From: Sue Howell
Sent: 04 March 2015 14:55
To: Neil Crowther
Subject: RE: Planning Consultation on Y/9/15/DOC (Rookery Cond Discharge)

Discharge of Planning Condition (10) (Ref Y/9/15/DOC)

Registered: 21-JAN-15
Site Address: Land Associated with Rookery Farm North of
A259 Flansham PO22 8NN

Application for approval of matters reserved by condition imposed under Y/14/14/ relating to conditions 3, 7, 10, 11, 12 & 14 for full details of external materials, inverter stations, transformers, substation, CCTV & securing fencing, precise height of solar panels, landscaping scheme, archaeological recording & monitoring, temporary arrangements for access for construction traffic & Construction Management Plan.

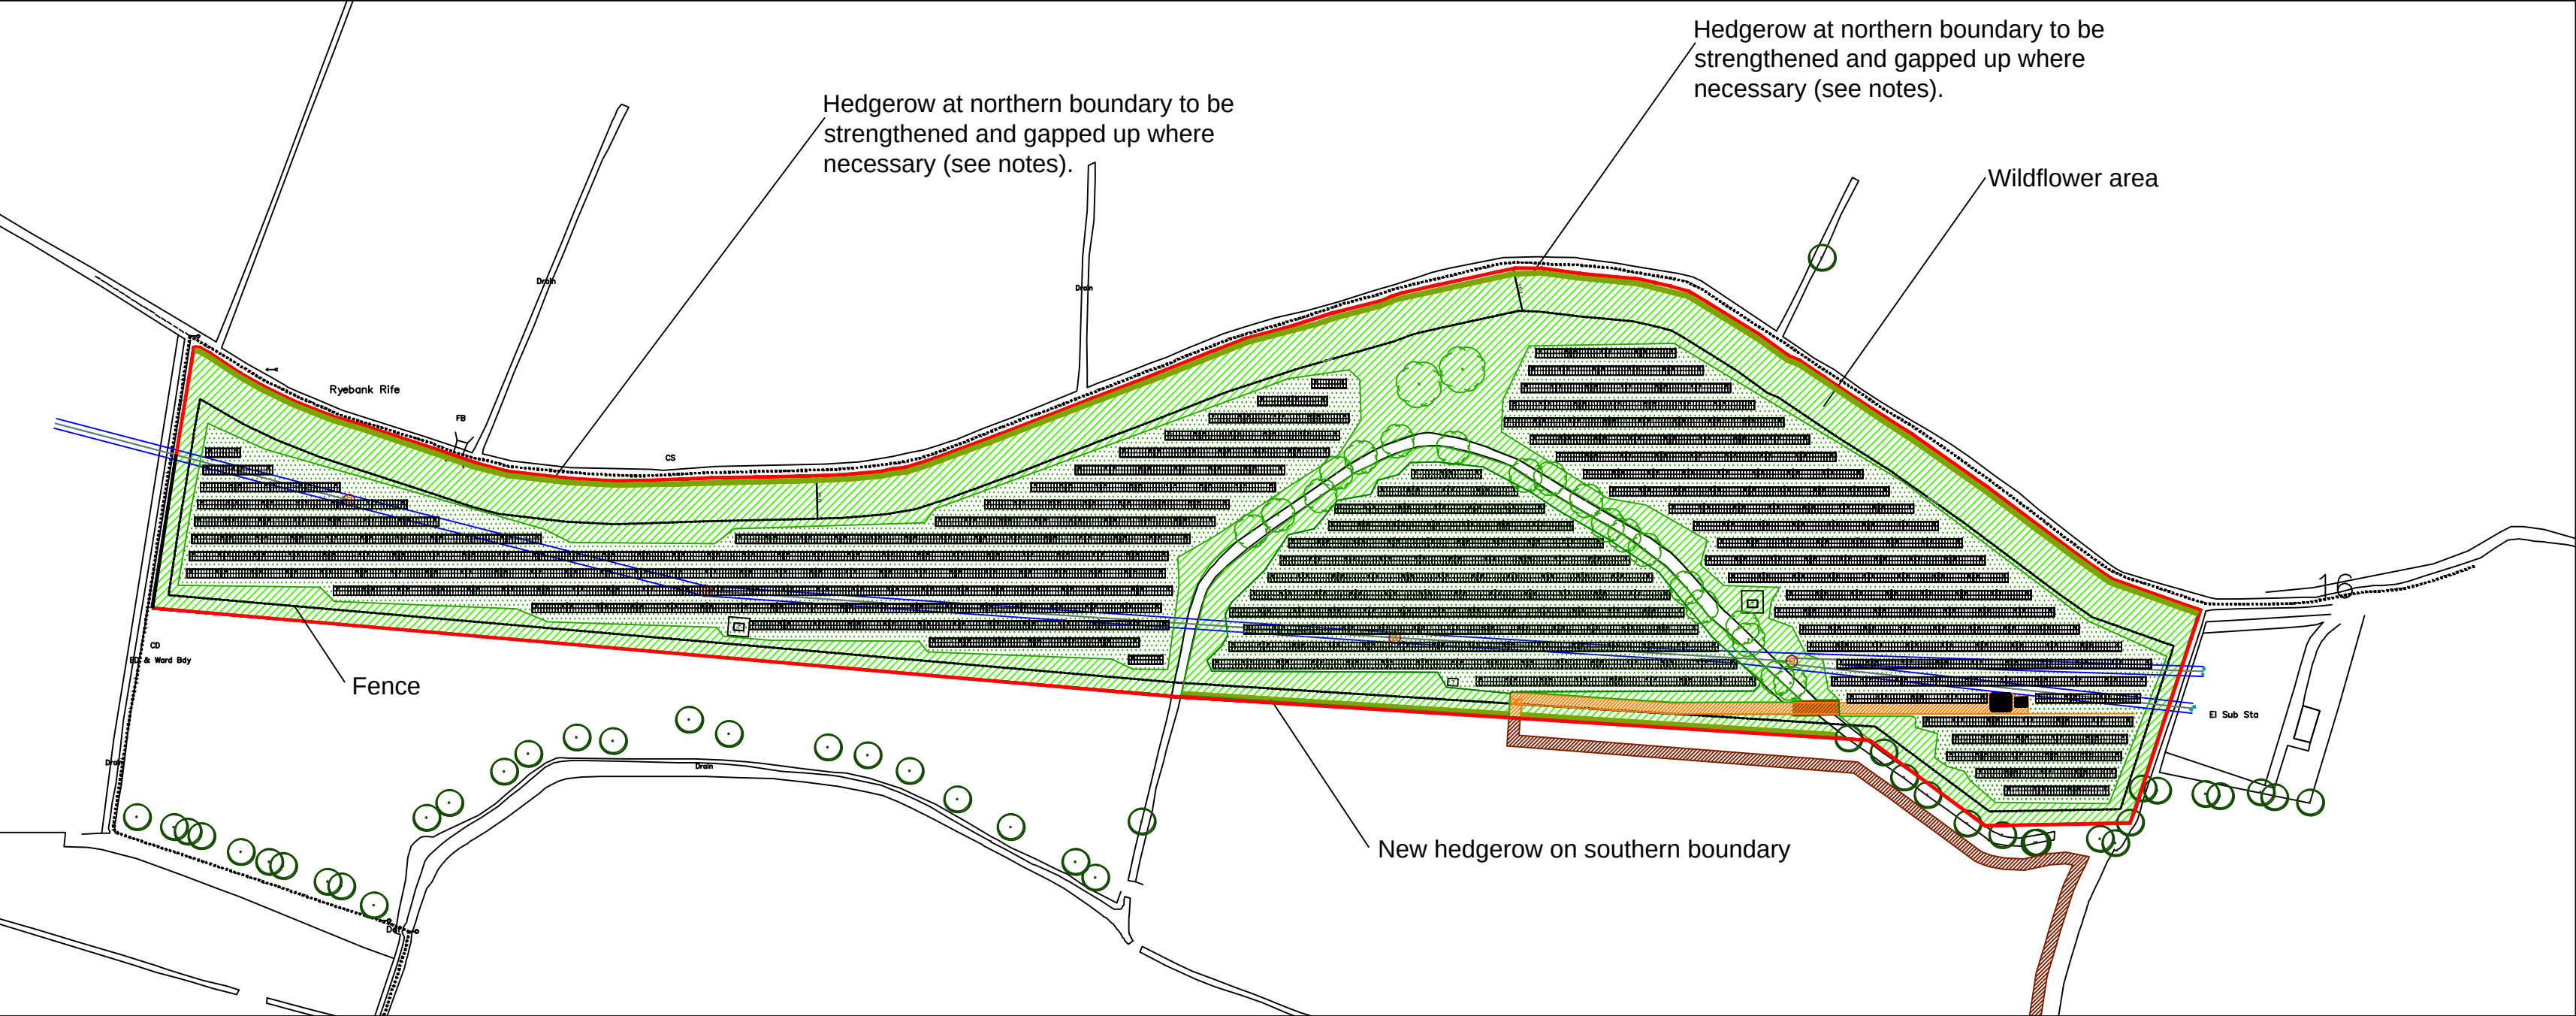
Landscape drawing LE12330-001 details areas to be planted and areas to be infilled along with an indicative species mix which does indicate size at time of planting and densities. **However** this plan is only indicative and needs to show this information plotted on the drawing with actual planting quantities rather than just the stated percentage composition.

We would not be able to recommend the discharge of Condition 10 on this application until the above information has been supplied for approval.

I have viewed the planting proposals which are now set out to confirm numbers of plants that will be incorporated into the scheme both for the new and gapped up hedgerow areas.

From the information submitted I would be happy to recommend the discharge of Condition 10 on this application, please re-submit your drawing through the normal planning portal, where I will be able to formally respond my recommendation.

As per our conversation yesterday we have now added plant numbers to the planting plan (attached). As discussed we have made a best estimate for the 'gapping up' planting to the northern hedge based on photography and mitigation proposals within the LVIA and a review of aerial views on Google Earth. In reality I think the 15% figure for gapping up will provide an over estimation of numbers required, however, this can be ground-proofed at the time of letting the landscape contract and plant numbers adjusted accordingly.
